CITY OF ALBUQUERQUE

September 23, 2022

**RE: Mister Car Wash
2161 Gibson Blvd SE
Grading & Drainage Plan
Engineer's Stamp Date: 07/25/22
Hydrology File: M15D021B**

SHEET NUMBER
C500

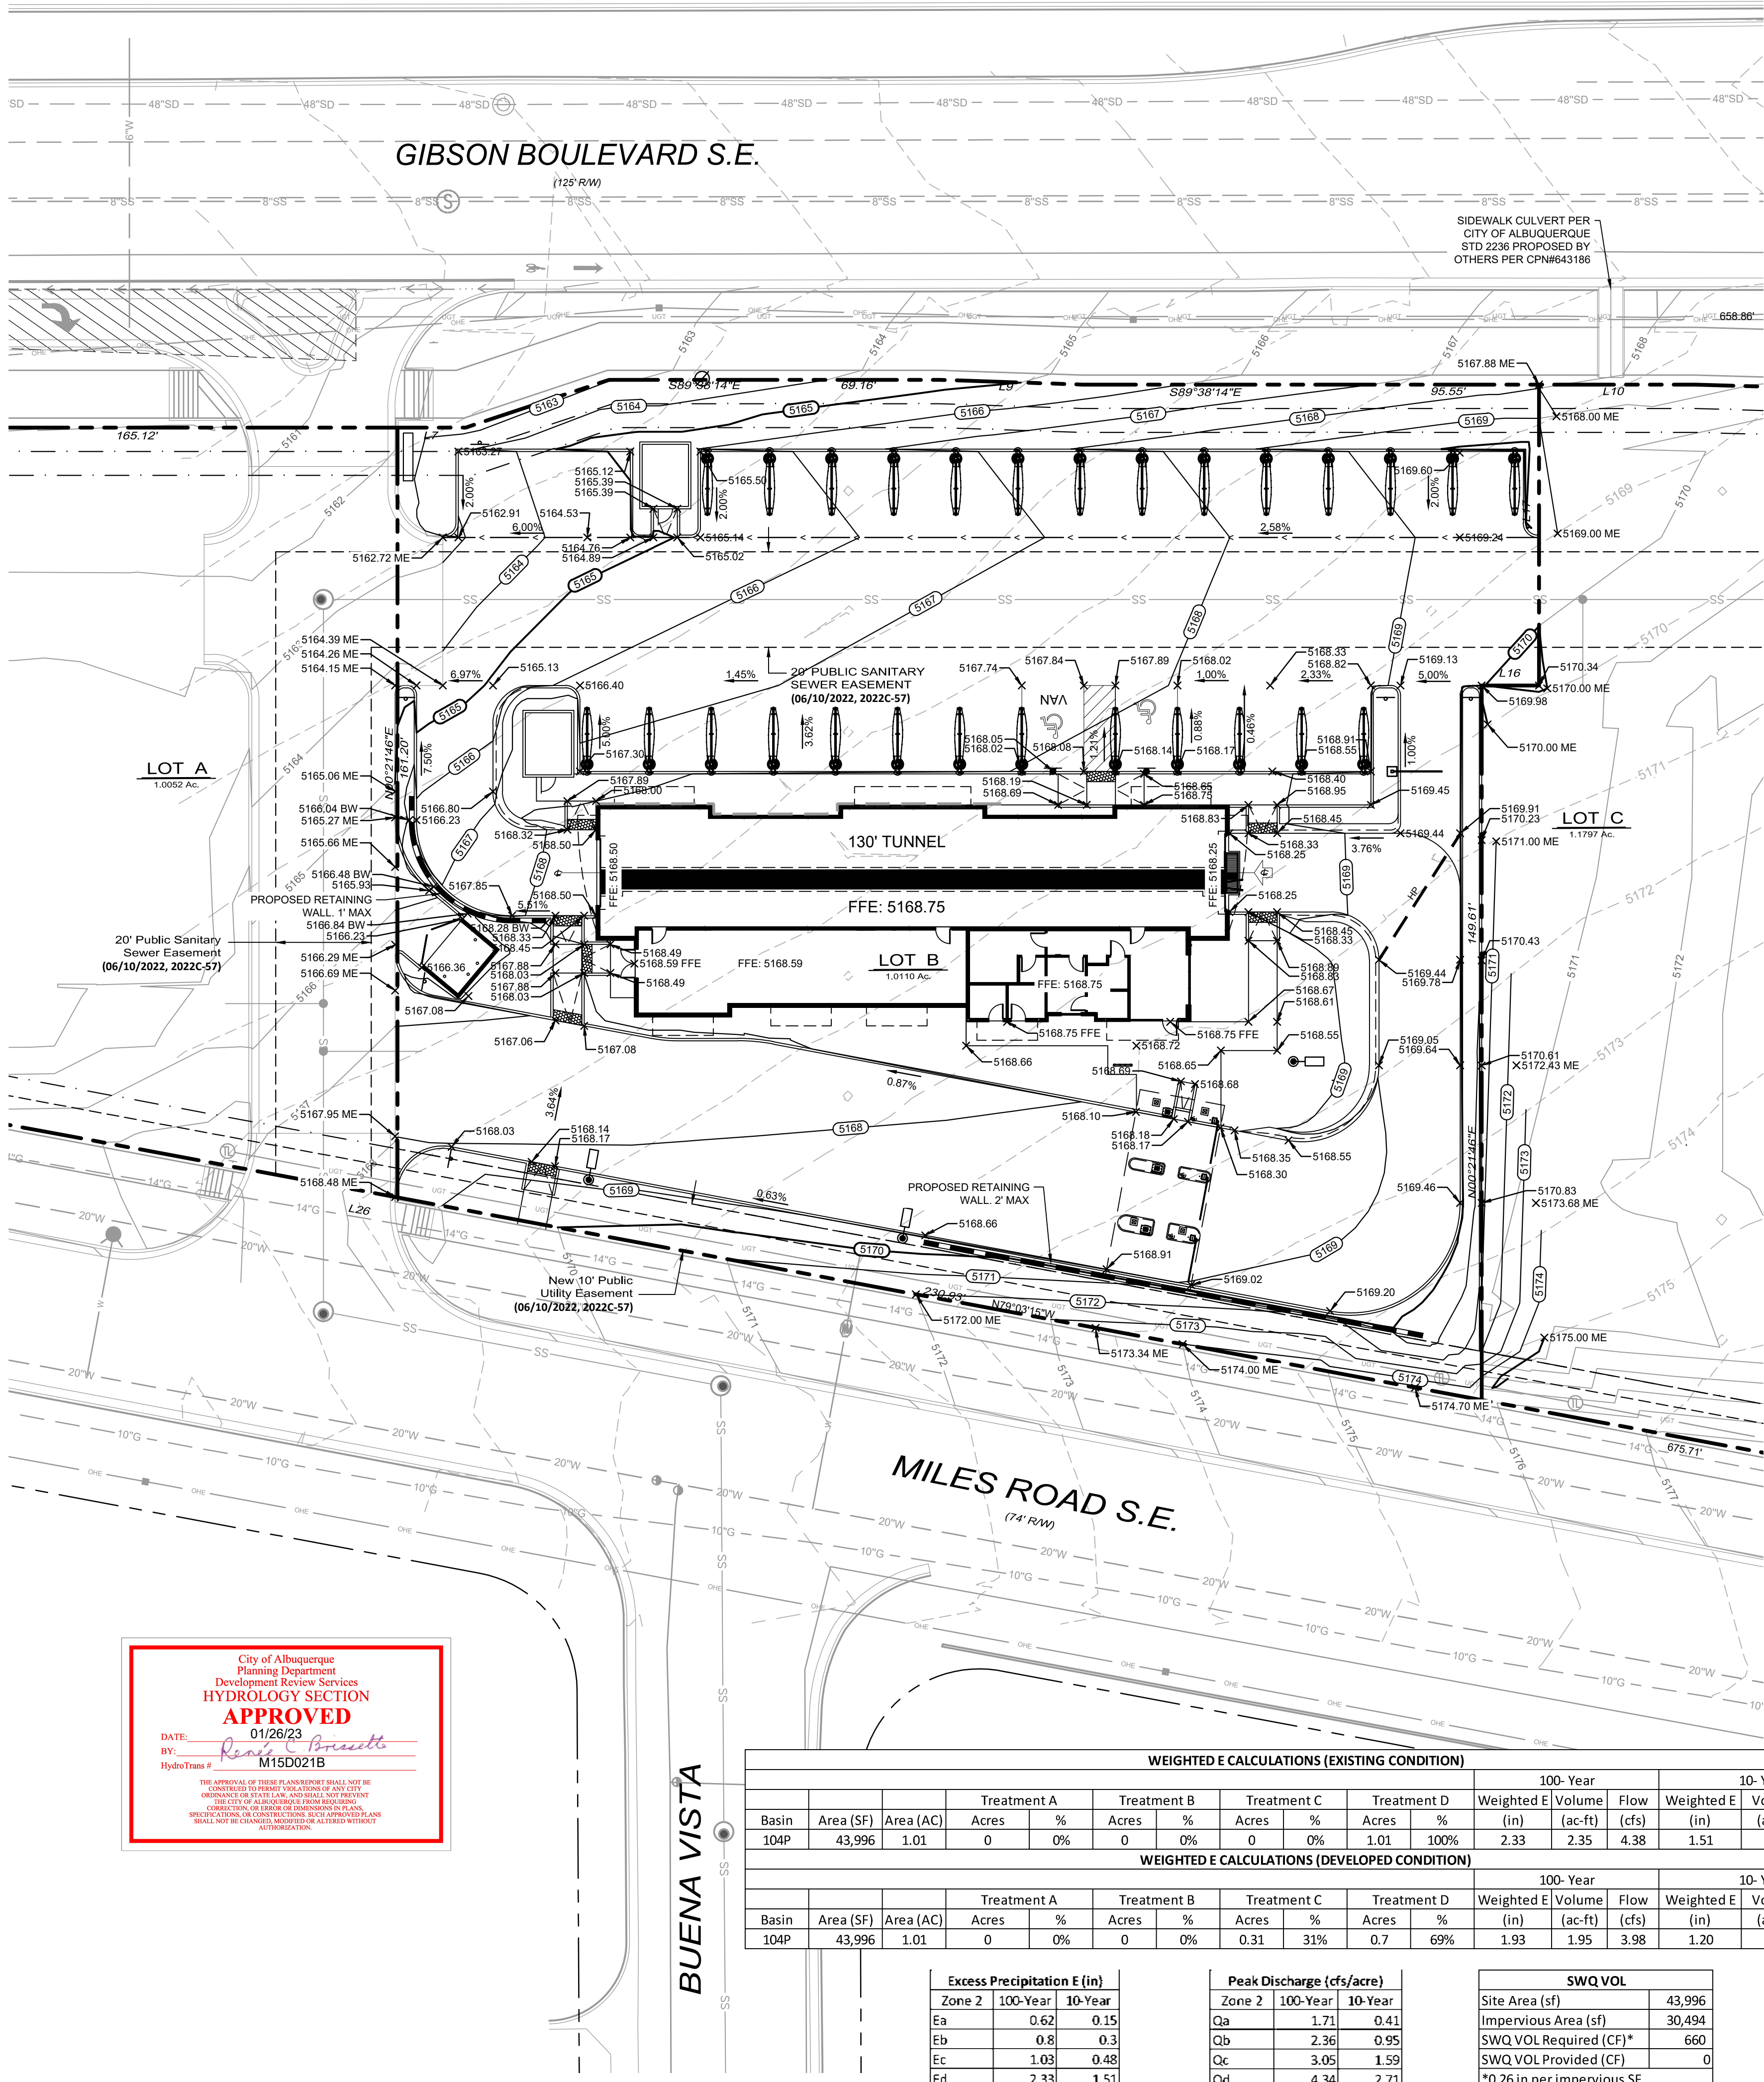
Grading Plan – C500

1. Per the DPM, the following must be on the Grading Plan. Please note the Grading Plan must be a stand-alone construction document.
 - a. Please provide a Vicinity Map. Typically, this is the Zone Atlas. This can be downloaded in pdf format from the City of Albuquerque's website.
 - b. Please provide the Benchmark information (location, description and elevation) for the survey contour information provided.
 - c. Please provide the FIRM Map and flood plain note with effective date.
 - d. Please provide a legal Description of the property.
2. Please reference City of Albuquerque standard detail No. 2236 – Sidewalk Culvert with Steel Plate Top at the sidewalk culvert. (see comment below for location)
3. Please add the attached SO-19 Notes.

Drainage Plan – C601

4. Please use the procedure for 40 acre and smaller basins as outlined in Development Process Manual (DPM) Article 6-2(a). Please provide both the existing conditions and proposed conditions for the 100 year-6 hour storm event.

5. Provide management onsite for the Stormwater Quality Volume (SWQV) in accordance with the Drainage Ordinance, § 14-5-2-6 (H) and the DPM Article 6-12 Stormwater Quality and Low-Impact Development for the sizing calculations. To calculate the required SWQV, multiply the impervious area draining to the SWQ pond by 0.42 inches for new development sites. Please show both the required and the provided volume.

6. The onsite drainage should be directed to the stormwater quality (SWQ) pond prior to leaving the site. Currently you have the SWQ pond on the high side of the site with little drainage going into it. Also, please show the top and bottom of the pond along with the volume for the pond. The pond also needs a spillway in the form of a sidewalk culvert at the SWQ water surface elevation on the pond side and match the existing gutter elevation in Gibson.

7. Please reference City of Albuquerque standard detail No. 2236 – Sidewalk Culvert with Steel Plate Top at the sidewalk culvert.
8. Please add either a concrete flume (channel) or a rock swale with curb cuts on either end so that the drainage can travel to the SWQ pond.

9. Please provide the weir calculations, per DPM Article 6-16(A), for the curb cuts and sidewalk culverts. A coefficient of 2.7 is typically used for the weir equation $Q = CLH^{2/3}$.
